Application No: EP/22/21/HH
Site Address: 15 The Plantation East Preston BN16 1LD
Description of works: Erection of rear extension and loft conversion with rear dormers and side gables

Thank you for your internet representation made on 24th April 2021 which has been recorded as an objection with the comments as follows:

8 East Facing front Elevation

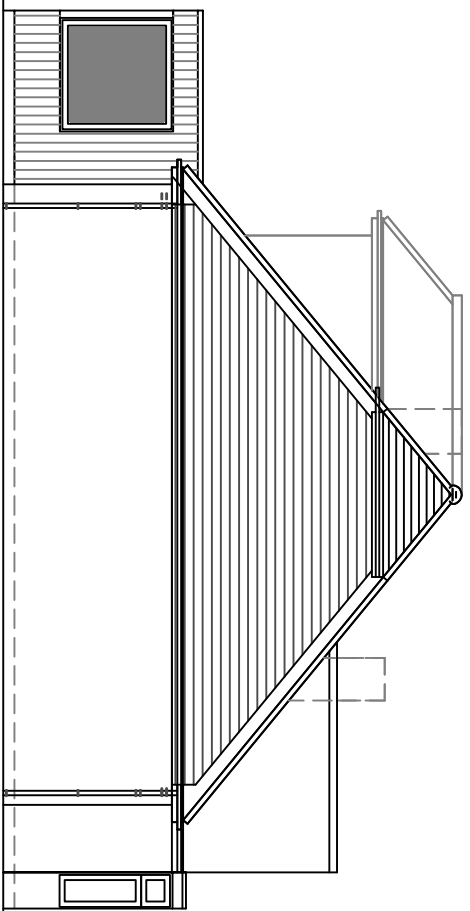
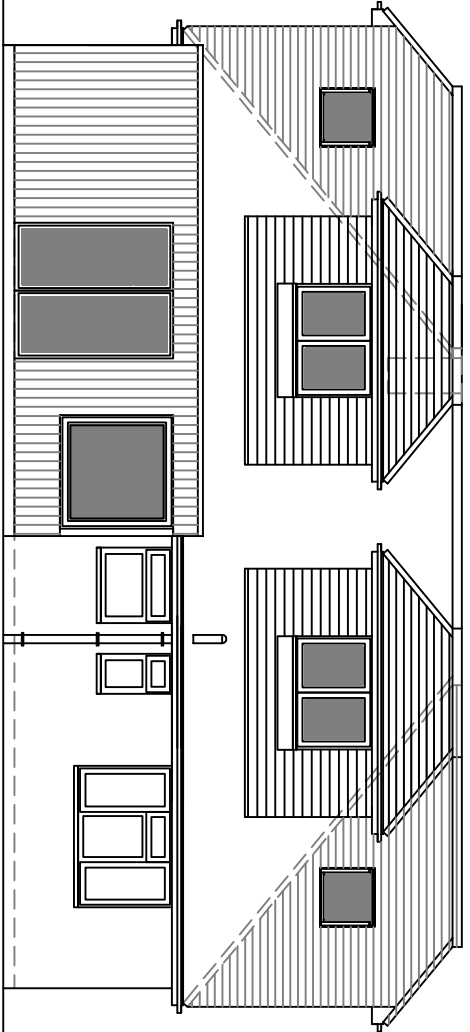
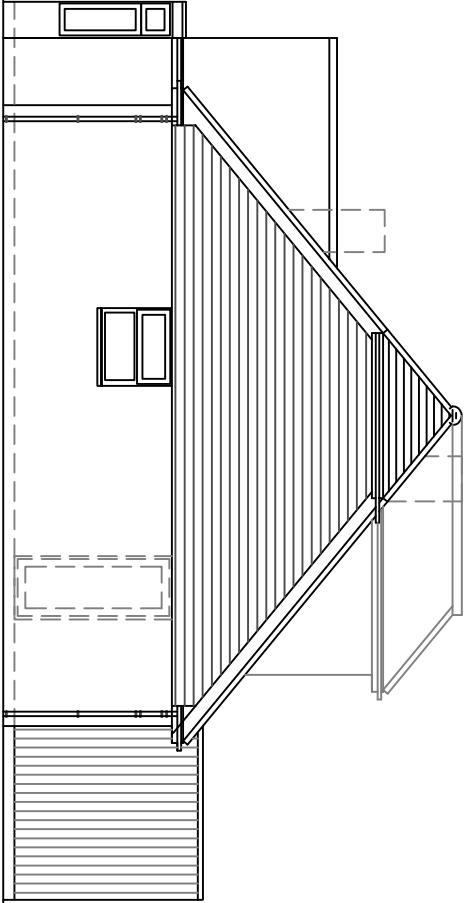
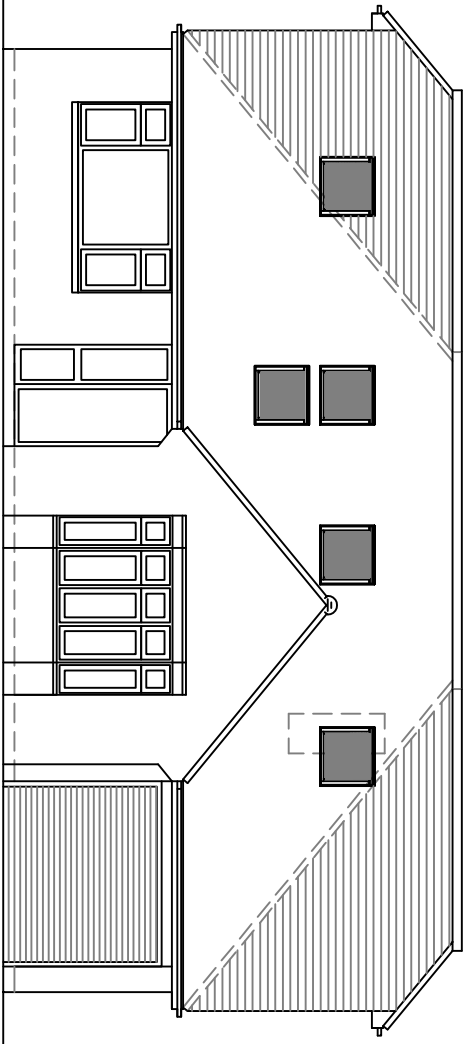
To change a 2 bed building into a large 5 bed building is out of character to the rest of the road. There is limited parking with no parking on the road at night. The extension of the side gables alters the appearance completely. The front will have 5 Velox windows with an extended roof line, the Dormers at the rear appear to have the same roof line.
